Ribble Valley Borough Council
Church Walk,
Clitheroe,
BB7 2RA

Phone: 0300 123 6780
Email: lhscustomerservice@lancashire.gov.uk
Your ref:
Our ref: LHS/CS/3/2016/0990
Date: 20th December 2016

Proposal:	Outline application for the erection of 18 dwellings (all matters reserved except for access).
Location:	Land to the North of Ribblesdale View Chatburn BB7 4BB
Grid Ref:	377132 - 444248

Proposed Access Arrangement

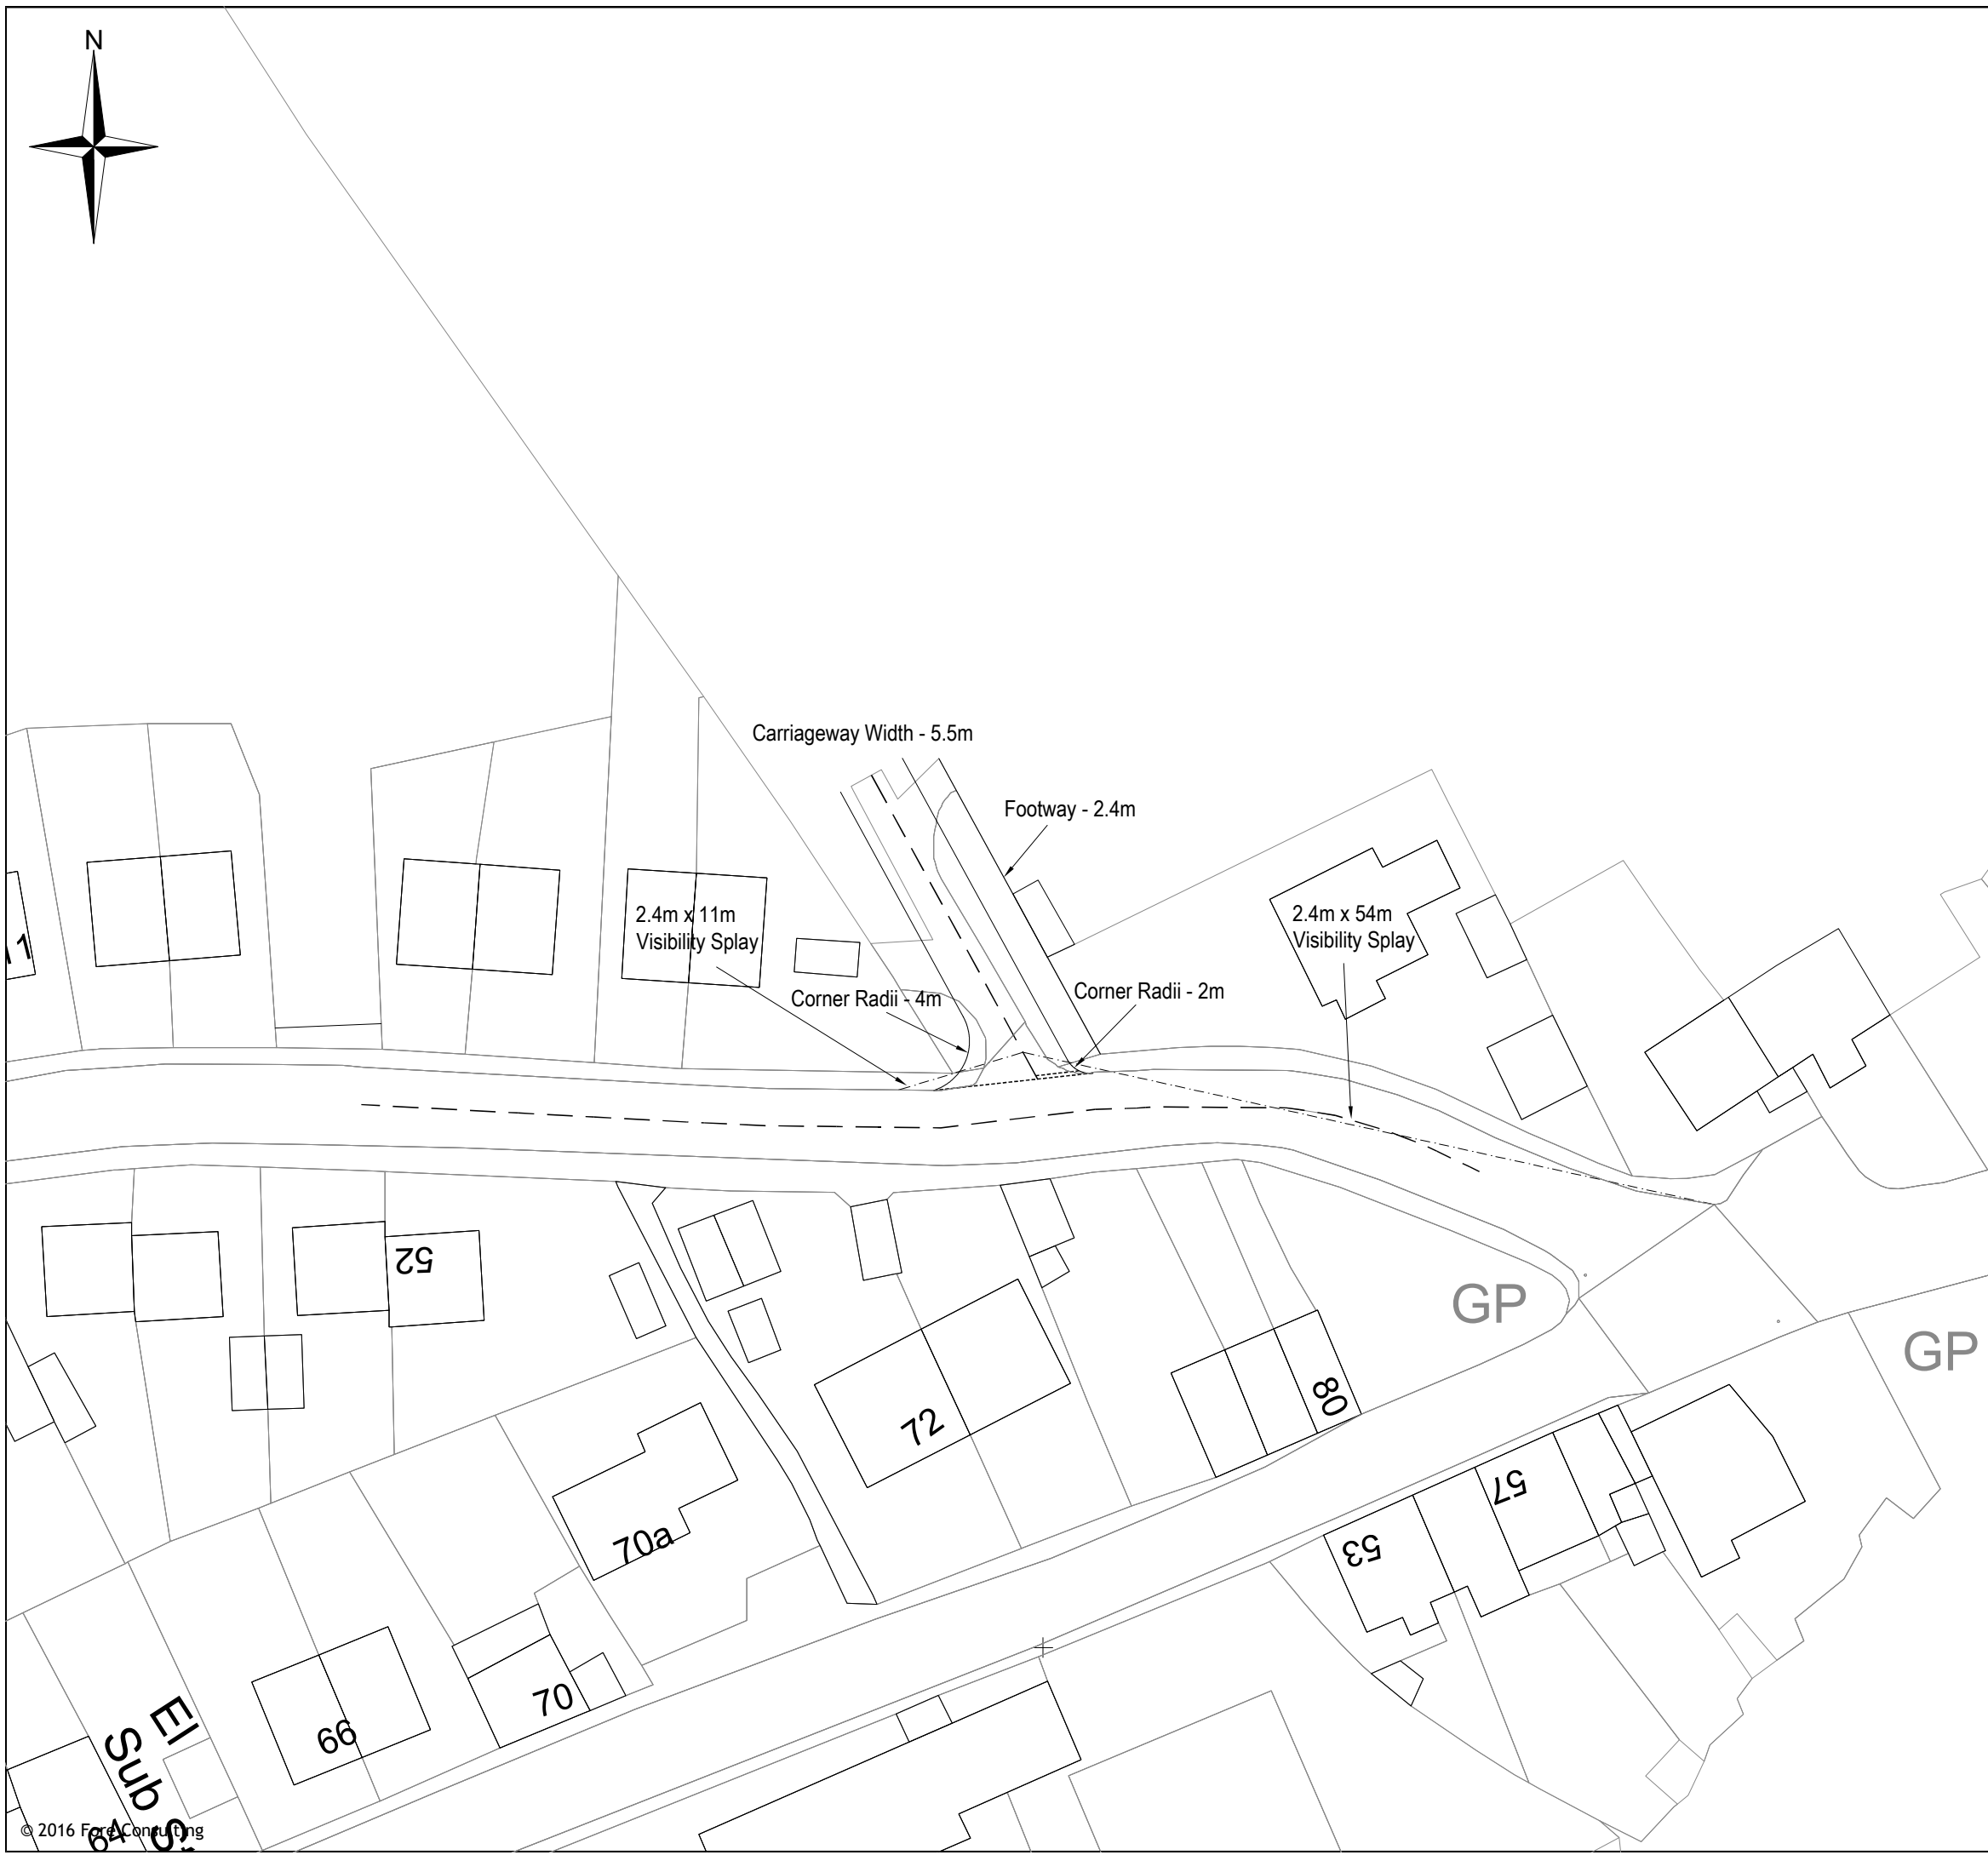
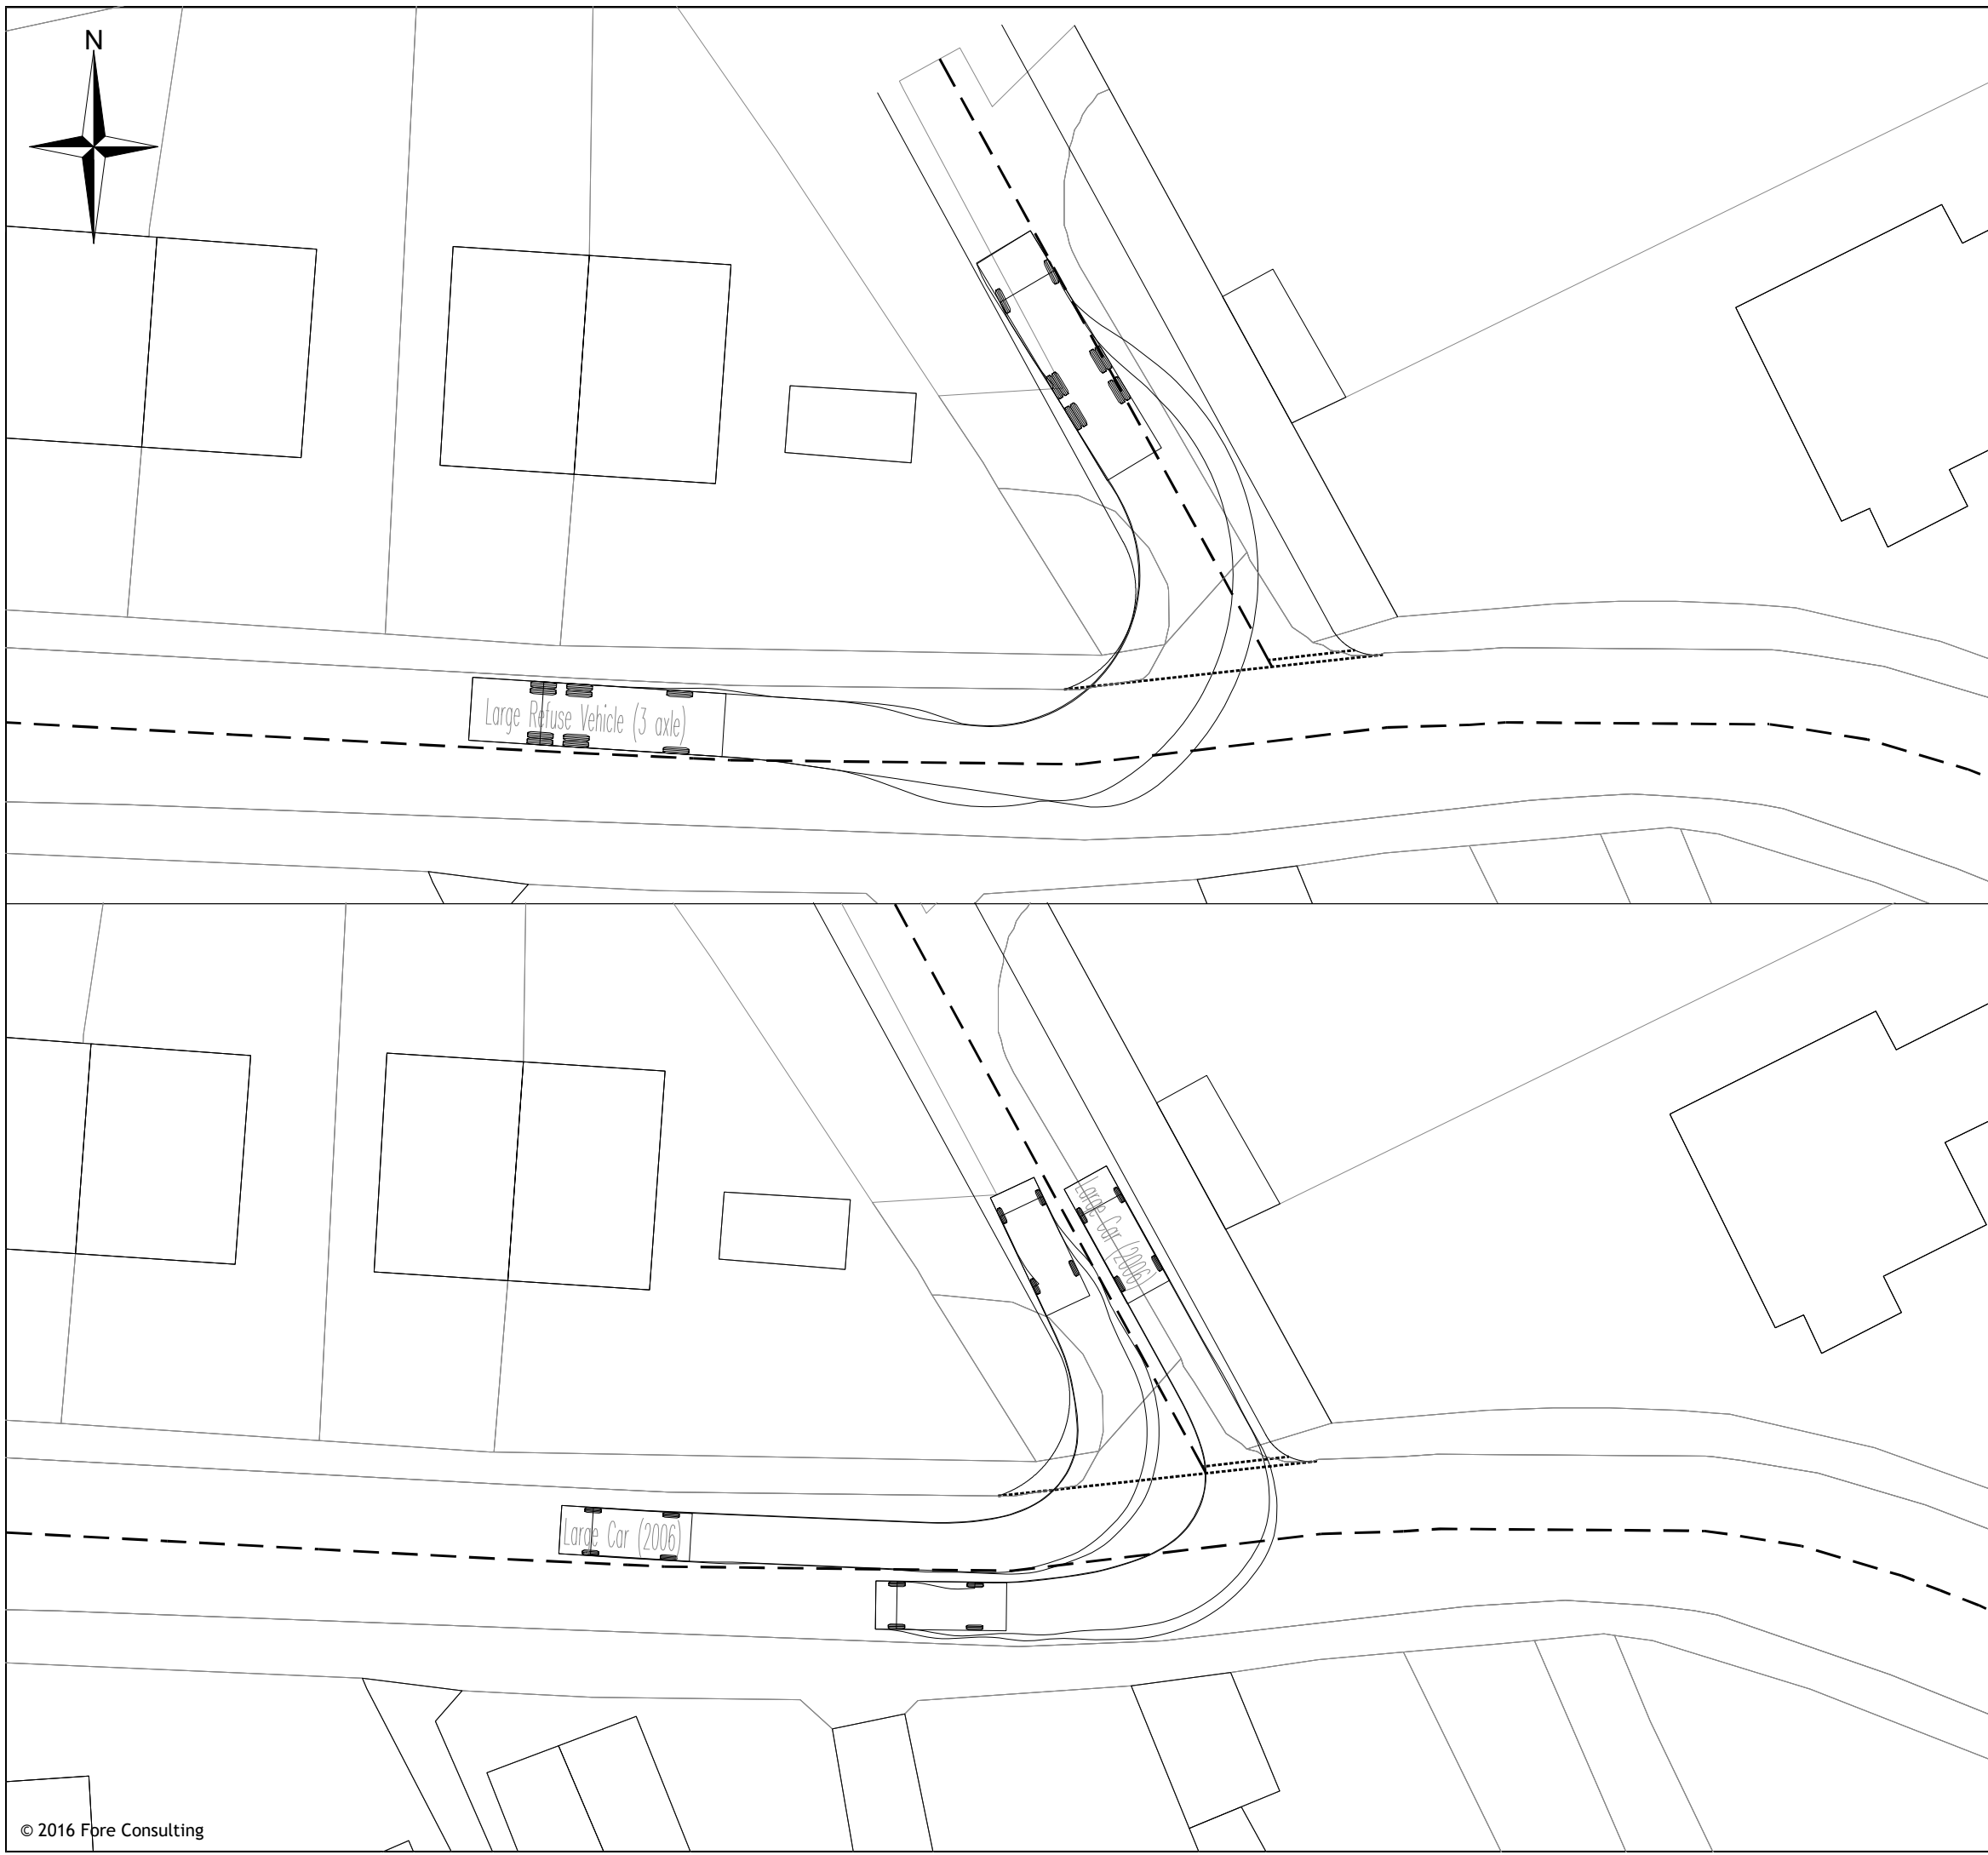
Based on the site visit, the Highway Development Control Section is of the opinion that the available sight lines from the private access road onto Ribblesdale View is acceptable, due to the gradient of the hill and the on road car parking.

The Highway Development Control Section is of the opinion that proposed site access layout is acceptable based on the site visit and the swept path analysis details provided by the applicant.

1. The new carriageway from the access to 25 Ribblesdale View to vary in width between 4.1 and 6m to allow passing and additional occasional parking a minor percentage of the road to be 4.1m wide. From Lancashire County Council Residential Design Guide.

4. The internal road to be designed to ensure that the vehicle speeds are kept below 20mph.
5. The existing access to be brought up to an acceptable construction and layout
